## **Stage 1/2 Road Safety Audit**

**Ballincor Wind Farm**

**On behalf of RWE Renewables Ireland Limited**

**April 2026**

R491 SITE ENTRANCE & VISIBILITY SPLAY
Scale 1:750

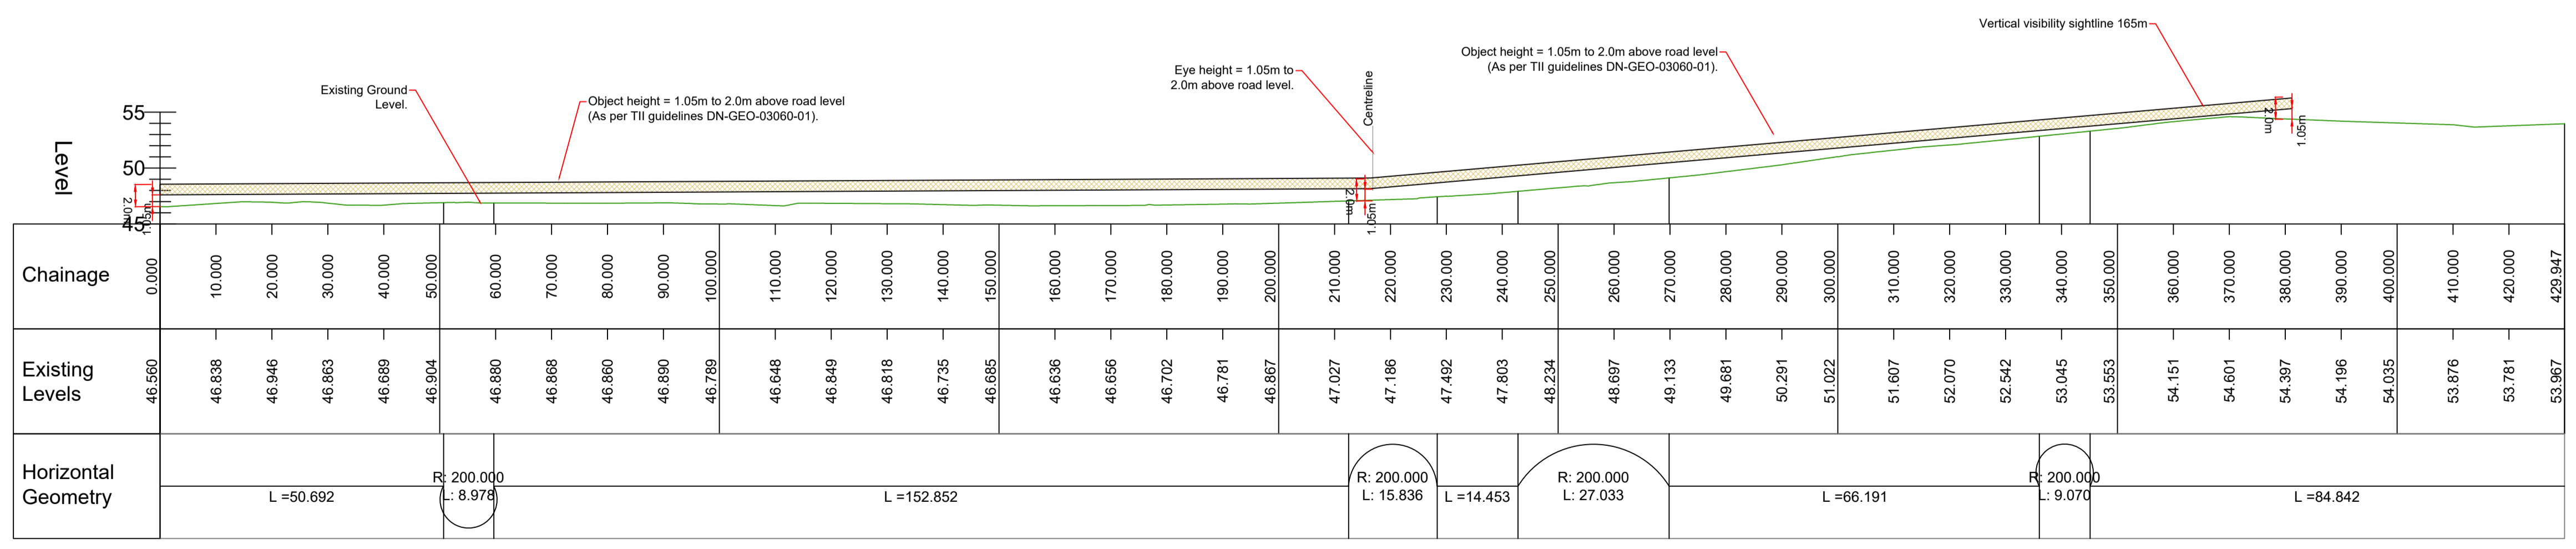
**Problem:** The junction visibility splays are indicated as 160m for the R491 and 90m for the L1071. The speed limit signs on these roads are 80kph and 60kph respectively. Site observations suggest the vehicle speeds might be in excess of these speed limits.

**Problem:** Forward visibility for R491 southbound drivers to a vehicle waiting to turn right into the development junction may be restricted by roadside hedging.

**Problem:** The R491 junction radii for the operational phase of the development appears large. There is risk development traffic may exit left off the R491 at high speeds and lose vehicle control. Additionally, development traffic waiting to enter the R491 by turning left may align their vehicle at an acute angle, thereby the driver being required to look over their right shoulder to view approaching traffic. The driver may not see smaller vehicles approaching i.e. two-wheeled vehicles.

4.1.1	Yes	No	Horizontal visibility of 215 m is achievable for both entrances. However, vertical visibility of 165 m on the R492 is only achievable to the right. Access No. 1 (R492) will be used solely during the construction phase, during which a temporary advisory speed limit will be implemented on the R492. 85 <sup>th</sup> speeds will be monitored here prior to opening the construction access. Additional temporary traffic calming will be implemented if necessary to ensure 85 <sup>th</sup> speeds are no greater than 80kph. In addition, a Traffic Management Operative (TMO) will be stationed at the entrance to ensure safe egress onto the R492, as set out in the Traffic Management Plan (TMP).	Yes

4.1.2	Yes	Yes		
4.1.3	Yes	Yes		
4.2.1	Yes	Yes		
4.2.2	Yes	Yes

L1071 SITE ENTRANCE & VISIBILITY SPY
Scale 1:750

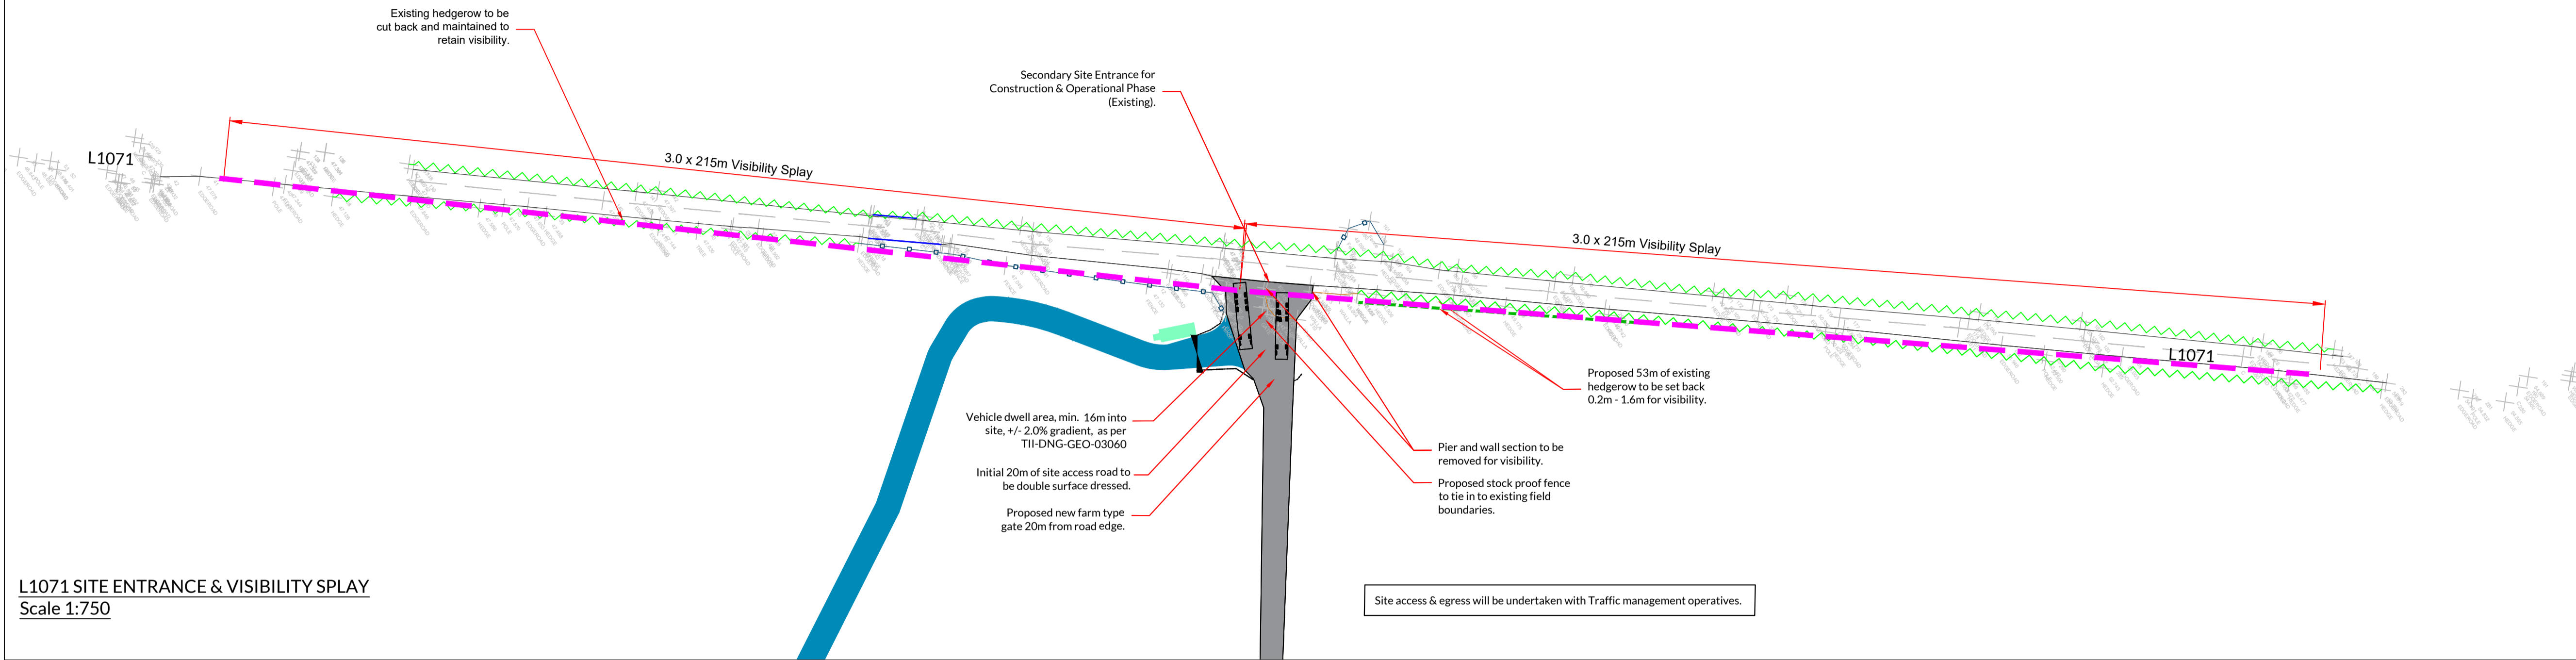
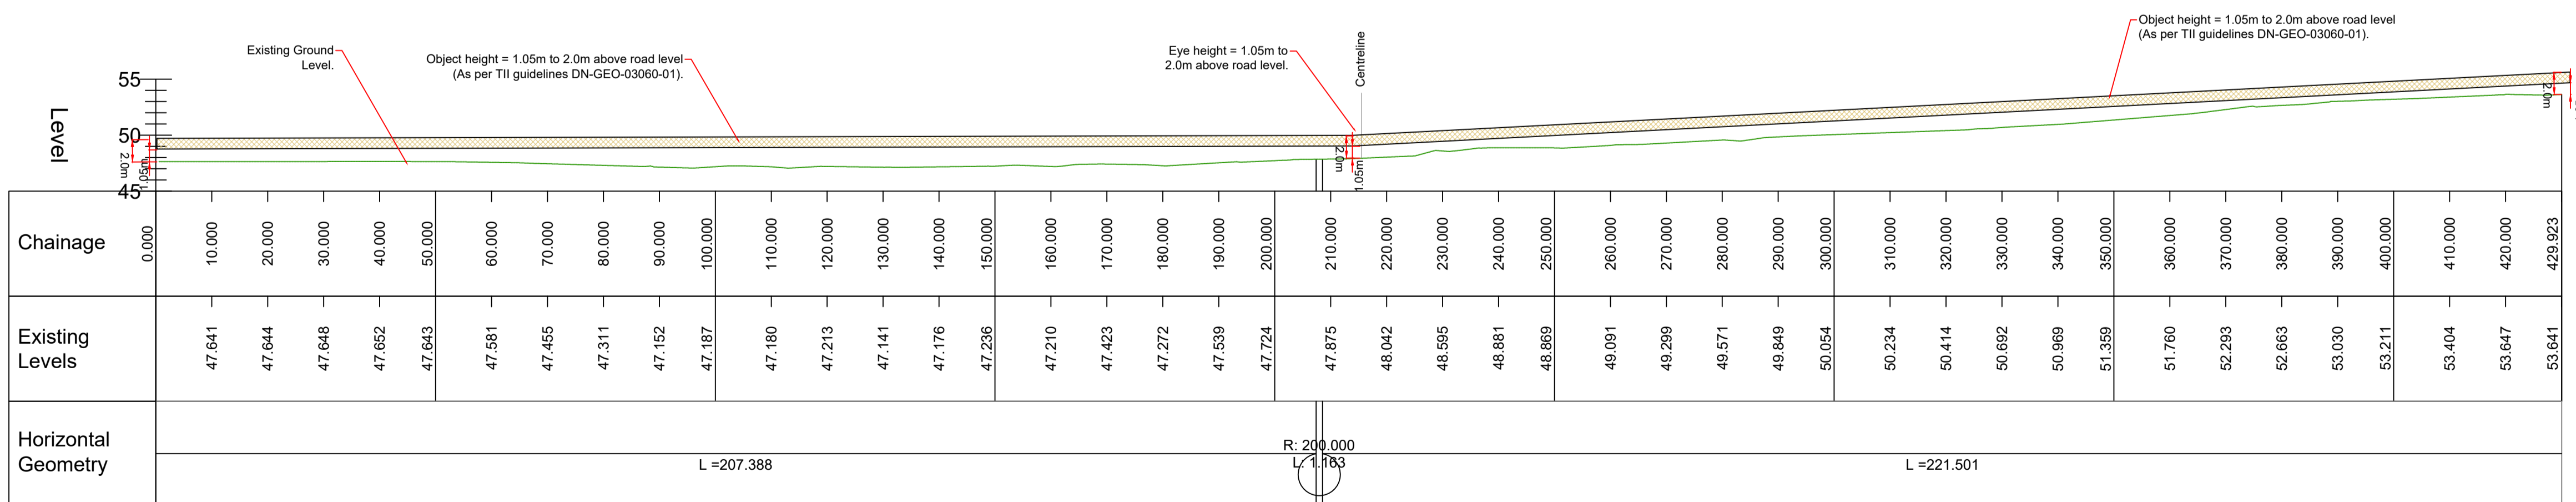
**Problem:** The development site access forms a junction with the farm access in close proximity to the L1071 carriageway. Development traffic may turn off the L1071 but may not be able to fully clear the junction due to farm traffic waiting to join the L1071.

**Recommendation:** The Design Team should amend the junction arrangement to ensure vehicles do not become stranded with the rear end protruding into the L1071 carriageway.
